Dear Miss Greenwood,
LA Planning ref: TBC – former ref FG/206/17/PL

Re: INSTALLATION OF SIX PUMP (12 FILLING POSITION) AUTOMATED PETROL FILLING STATION, & ASSOCIATED AIR/WATER SERVICES.

LAND AT ASDA SUPERSTORE LITTLEHAMPTON ROAD FERRING BN12 6PN

This letter has been updated for the new automated petrol filling station application, but makes reference to conditions and details previously requested in application your reference HA/2018/120208/01-L01.

Title
Tank Farm general
arrangement

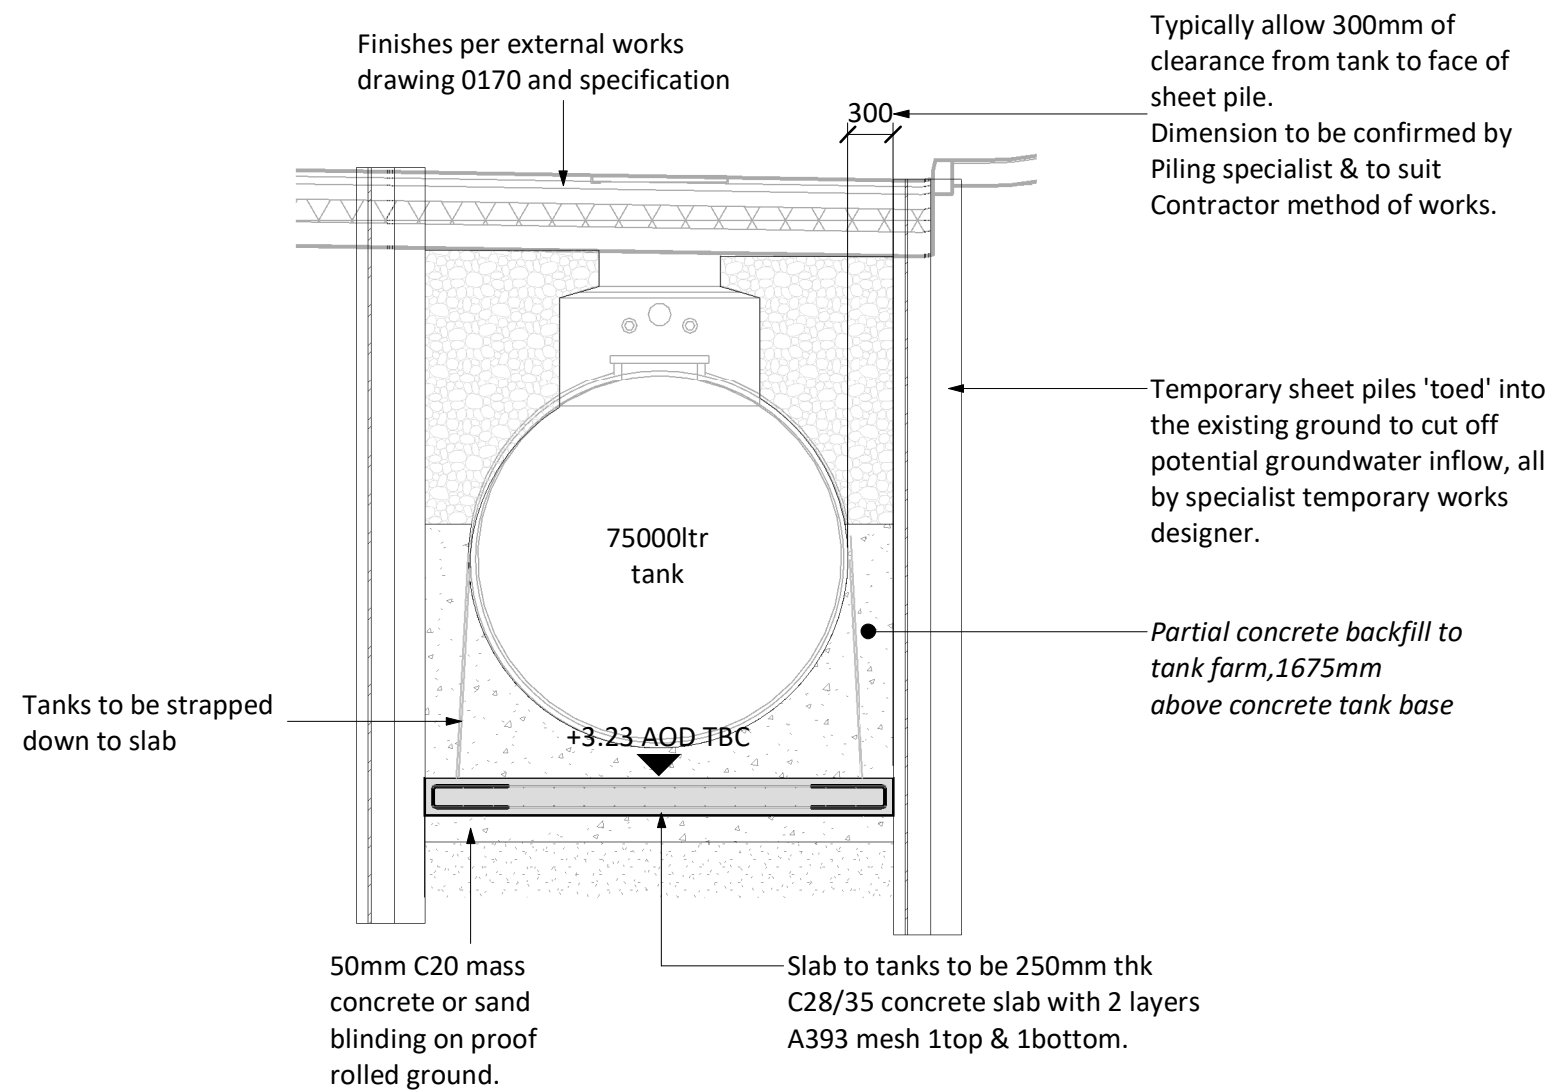
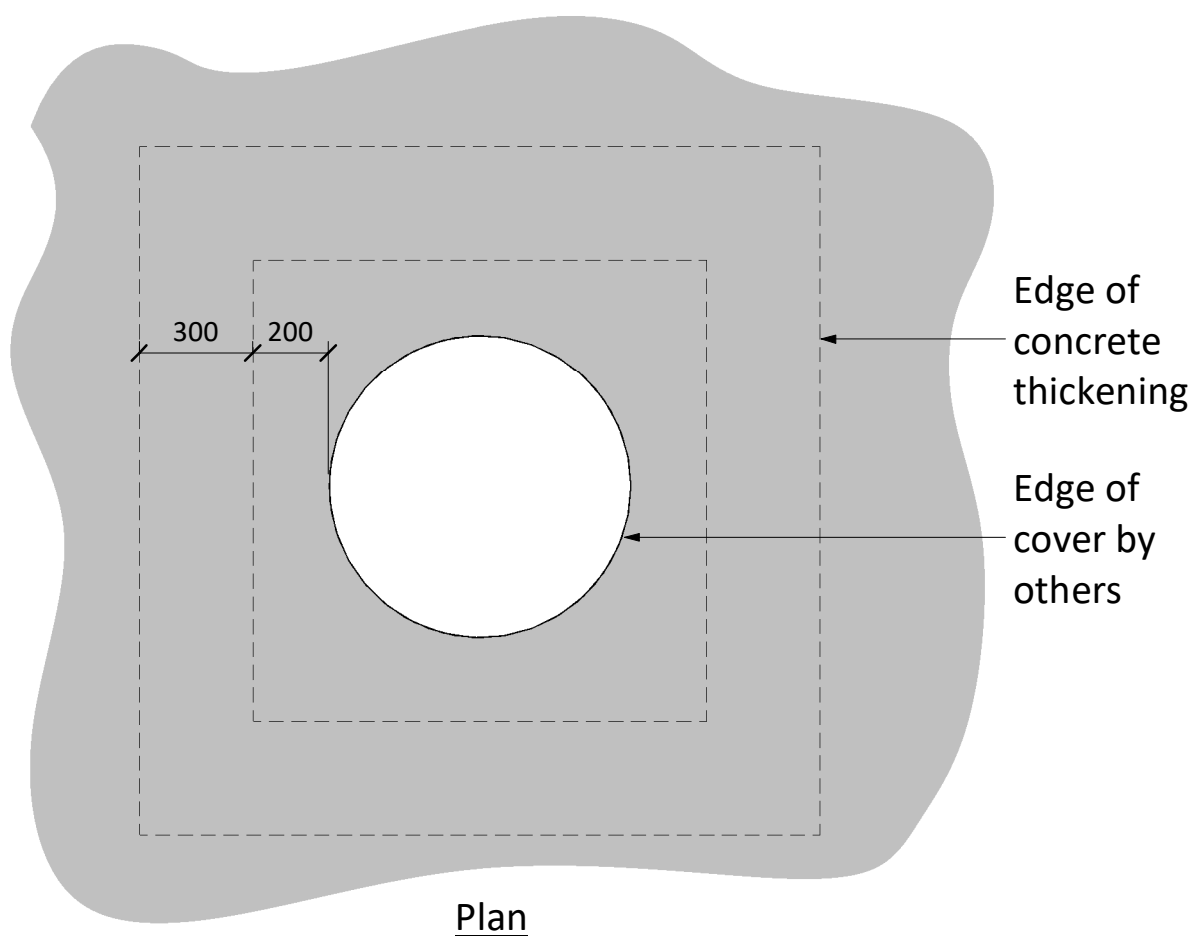
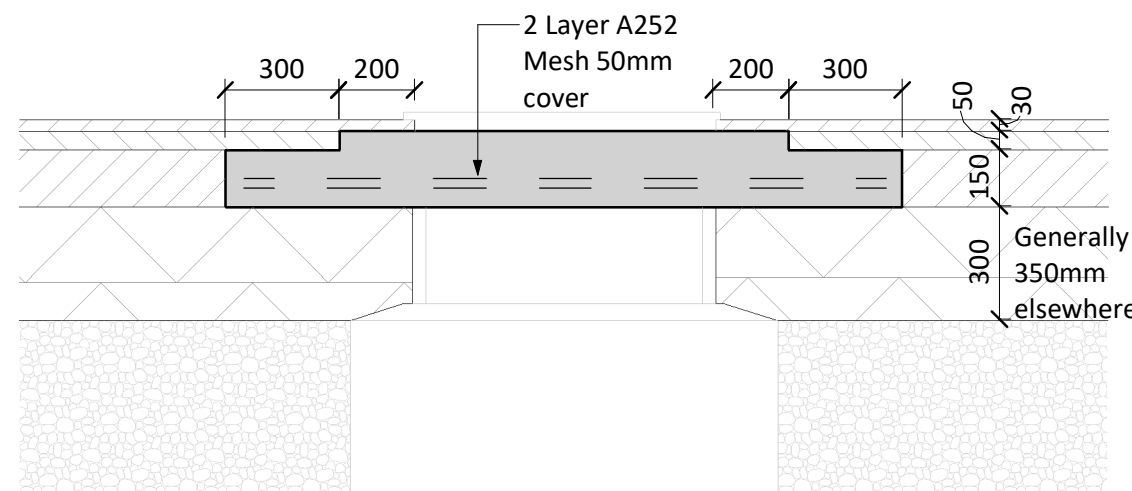
The proposed design of the underground tanks is inadequate. As the proposed tanks are to be developed below ground, groundwater levels may be such that they are sited below the groundwater table. We therefore recommend that the applicant addresses this environmental risk, particularly with our Position Statement D2 and present a design that mitigates against any future pollution.

1. *In order to fulfil the guidance in the Blue Book and taking into consideration removing the tank at the end of its life, what evidence is there to support the need for a concrete backfill? Have any structural engineers done calculations based on ground conditions at this site?*

The tanks have been located in a linear format to the most Northerly part of the site (refer to '400__02 Geo-Environmental Appraisal Section') which ensures that the below ground tank installation does not a) breach the superficial clay barrier into the chalk layer below and b) is not situated below the groundwater level.

Due to the inconsistent perched water within the superficial clay layers & environmental sensitivity, it has been concluded to increase the protection around the proposed tanks by backfilling 2/3 of the tank height with concrete. In terms of structural justification; due to the tanks being installed within the firm clay substrata layers it is necessary for the underground tanks to be encased in concrete to stop potential floatation should any perched groundwater permeate its way from ground sources into the tank farm excavation once backfilled at a time when the tanks are empty. Due to the heavy nature of the clay material there is potential for the tanks to be surrounded in groundwater with no means for its disposal through the firm clays. To negate this potential risk, it is proposed to concrete fill around the tanks so that ground water does not have the potential to affect the tanks when empty.

As stated above; due to the tanks being installed within the firm clay substrata layers, it is necessary for the underground tanks to be encased in concrete to stop potential floatation should any perched groundwater permeate its way from ground sources into the tank farm excavation once backfilled at a time when the tanks are empty. Due to the heavy nature of the clay material, there is potential for the tanks to be surrounded in groundwater with no means for its disposal through the firm clays.

To negate this potential risk, it is proposed to concrete fill around the tanks so that ground water does not have the potential to affect the tanks when empty.
